**Consultation Response from KC,
Lead Local Flood Authority**

2024/90859 Land at, Ash Street, Birkby, Huddersfield, HD1 6HN

**Outline application for the demolition of buildings and the erection of light industrial units
(Class E (g) (iii))**

Date Responded: 24th June 2024

Site Plan - As Proposed

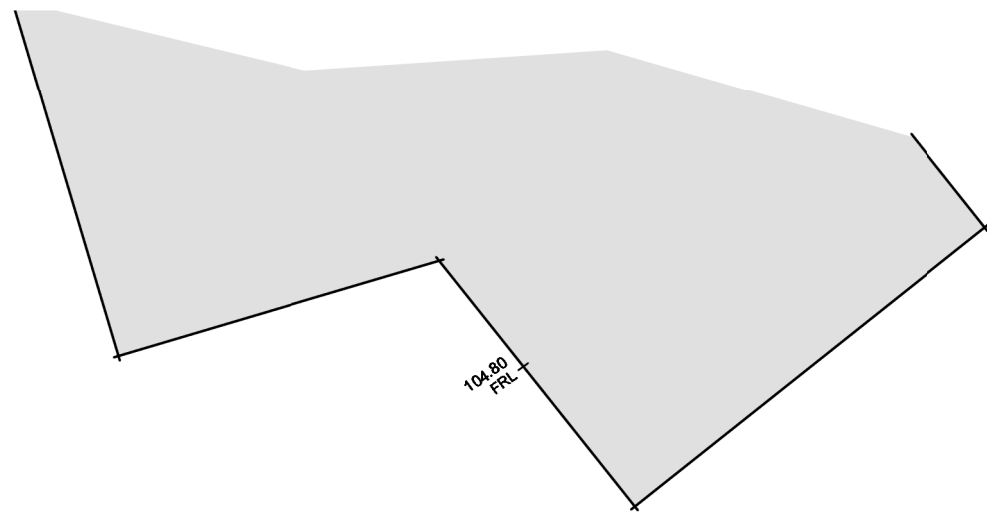
The application for indicated a surface water connection to soakaway and watercourse is intended but not sewer.

British Geological Survey results for the area indicate a level 4 suitability for the use of infiltration techniques, i.e. serious constraints. We therefore rule out this use of such methods.

A connection to main river immediately to the south of the site is feasible but will require permission off 3rd part landowners to connect to. In addition, any connection here would be subject to a discharge restriction of 3l/s.

Ash Street does not appear to be positively drained. New units and associate parking will require drainage installation to prevent run off to neighbouring land. A feasibility study is therefore required to show a connection to watercourse and that space can be made required attenuation.
